Department of Primary Industries

OUT13/4864

24 APR 2013

Thank you for your letter of 28 February 2013 concerning the review of the Agricultural Impact Statement (AIS) for the proposed Watermark Coal Project (SSD 4975).

Figure 6A: On-site Biodiversity Offset Areas

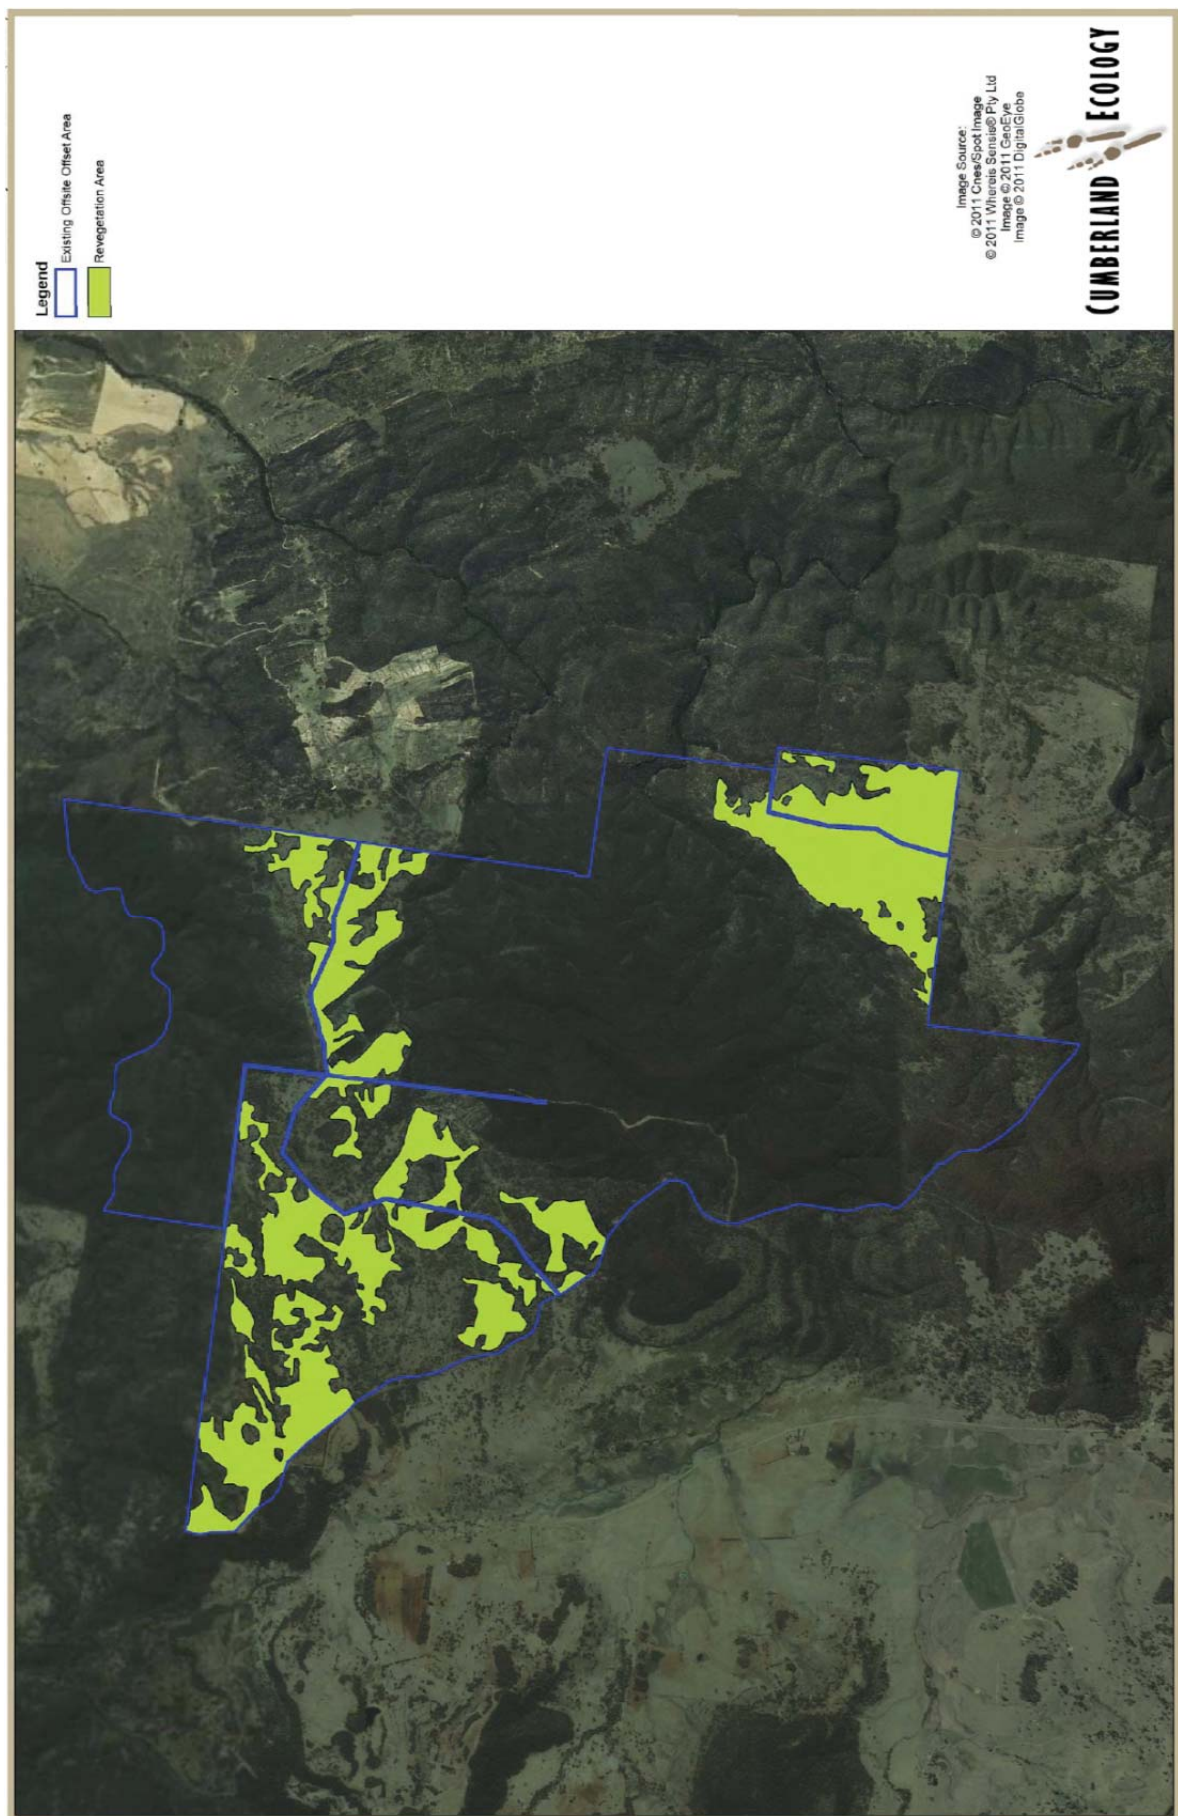
In addition, the Watermark Coal Project includes 696 hectares of BSAL in the biodiversity offset areas. BSAL land should be retained for agricultural productivity and not be included in any biodiversity offset areas.

- BSAL is included in the mining offset area (Ap. Y, p. 67). There is a calculated BSAL area of 696 ha (fig 10) in offset areas. This should not be used as a biodiversity offset and should be retained as agricultural land.

- 696 ha of BSAL is included in the biodiversity offset area (Ap. Y, p. 67-68). BSAL should not be included in biodiversity offset areas and should be retained as agricultural land.

- a) the disturbance boundary (including active mining areas, overburden emplacement areas and infrastructure areas; and
- b) any biodiversity offset areas.

Figure 10A: Conceptual Final Landform and Land Capability

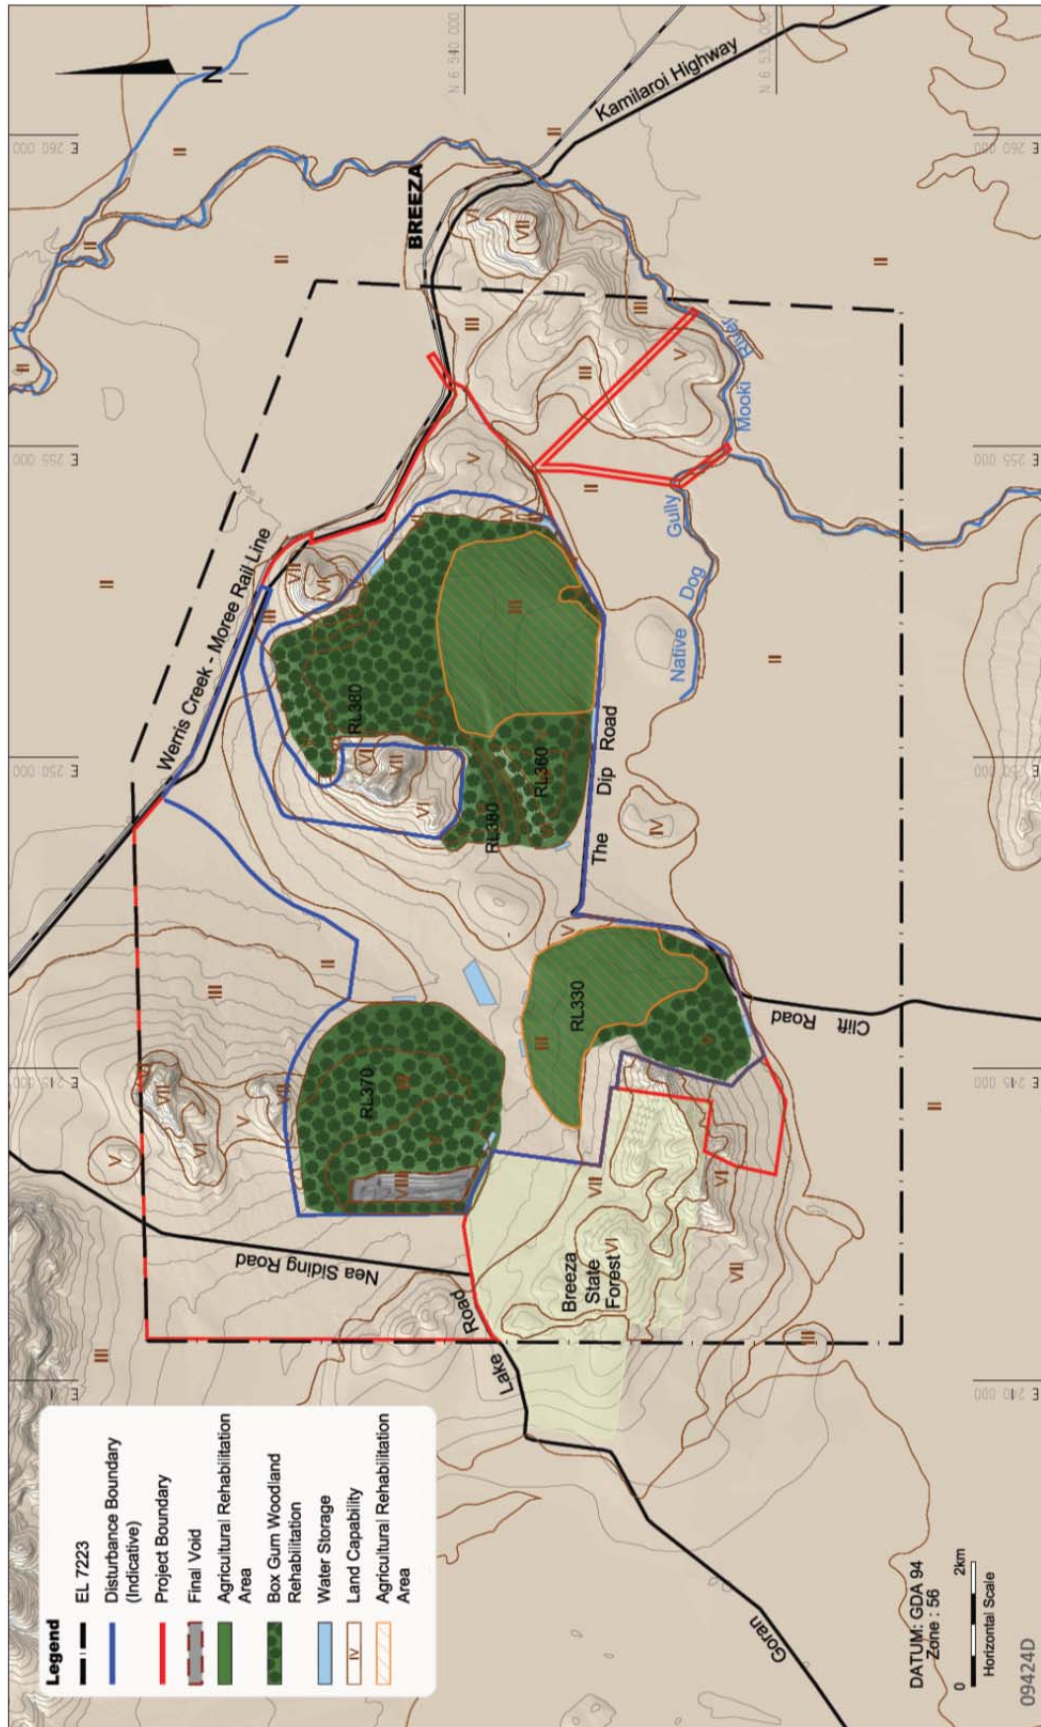
It is assumed that this difference in land area includes the rail loop, infrastructure areas, the main dam and haul roads which still exist on site on the conceptual final land form (Figure 29 Ap. Z). This conflicts with Figure 7 Ap. Y, post-mining agricultural land capability. The Office is concerned that this infrastructure will remain on land capability class II and III rendering it unusable for agriculture.

- 3c** - That the total disturbance area is clarified;
- 3d** - That the total rehabilitation areas of each land capability class, post-mining be clarified and shown on a map;

- 3e** - That any land capability class II areas be completely excluded from the mining disturbance area and from soil stripping areas;
- 3f** – an explanation is provided on how land outside the mining voids but still within the disturbance boundary (rail loop, infrastructure areas, dams and haul roads) is to be rehabilitated.
